Planning Services
Kirklees Council
Huddersfield
HD1 9EL

23rd August 2024

Planning objection – 11 Wood Street 4 no. Residential Dwellings - Planning Application reference 2024/62/91934/E

APPENDIX 5
TREE IMPACT PLAN

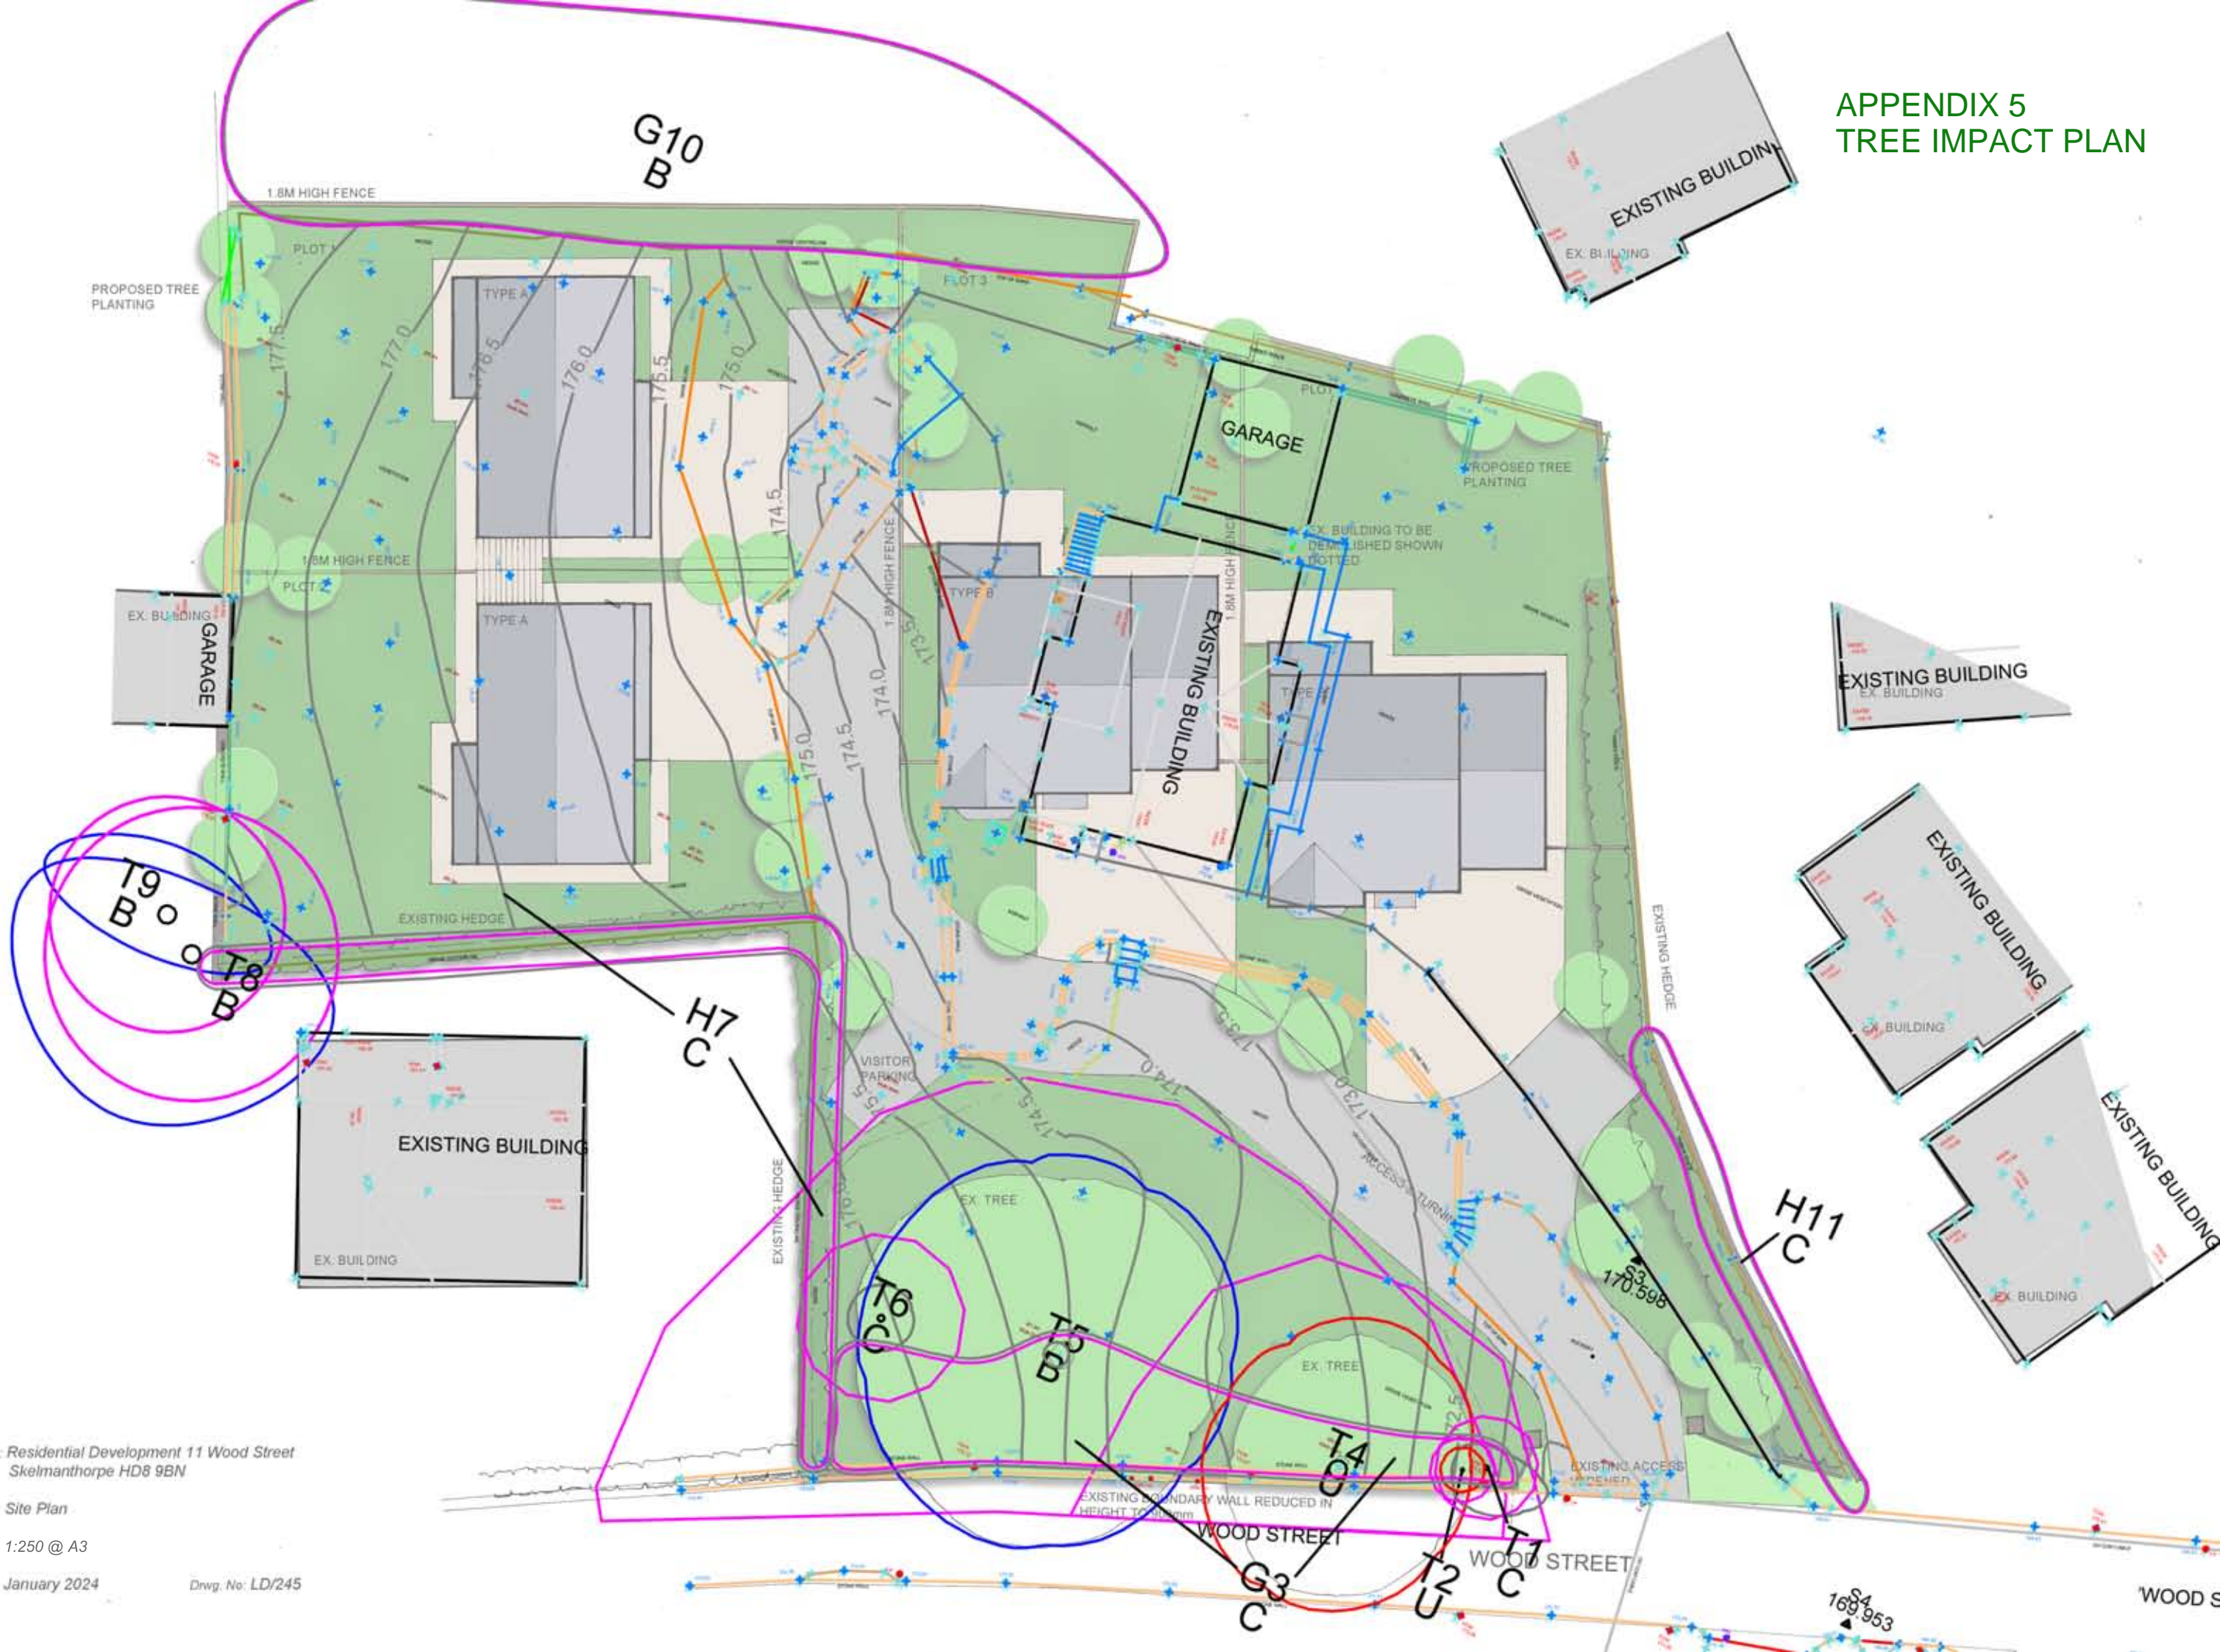
Furthermore, the risk to the established TPO'd trees on Wood Street is significant, because of the proposed layout, and proposal to reduce the height of the wall by an amount that still does not achieve visibility requirements. This is exacerbated by the visibility splay drawn by the applicant's consultant, which goes straight through the trunk of a TPO'd tree, this makes the loss of these trees more likely, **which would not be**

The proposal as submitted proposes to retain the trees whilst also removing a large section of retaining wall that contains the ground that supports the tree root structure. The visibility splay submitted by the applicant demonstrates that the tree cannot remain and the height of the wall should be reduced further to achieve the visibility splay requirements.

Application reference 2023/62/91649/E specifically considered the loss of trees on this site and following expert advice the trees shown on the proposed plan were considered necessary to be retained. Based on the submitted plans it is not clear that these can be retained and I am not confident that these trees will remain as presented by the applicant.

The turning head for delivery vehicles is at the entrance to the site, maximising the distance a vehicle has to reverse to service the site, this should be minimised.

Swept path analysis is required to show a typical delivery vehicle (7m long) can enter and exit in a forward gear. Delivery vehicles may enter the development and reverse into Wood Street when they cannot turn, or they may park on Wood Street, affecting the visibility splay, either blocking two way flow or opposite existing driveways.

The level difference between the proposed turning head and the gardens related to the neighbouring residential property is significant, errant vehicle protection would be required to prevent vehicles using the prescribed turning area and ending up in the hedge or in the neighbours garden.

The road layout is made up of various radii, this increases the swept path requirements for vehicles, reducing the potential to pass parked and moving vehicles. This increases the propensity for vehicles to park on Wood Street rather than on-site.

The road width behind the driveways is narrower than 6m, therefore parking space widths must be increased.

The existing hedge between the house and existing dwellings to the east has been reduced in width, no additional measures are proposed to reduce headlights on vehicles using the proposed access road and turning head from causing nuisance at ground and first floor on existing neighbouring dwellings.

There is space within the site to accommodate a bin store within the carry distance set out by Kirklees Council, which would remove the need to store 3 no. further bins on Wood Street on the day of collection, which would likely interfere with visibility splays and would affect the potential for two vehicles to pass.
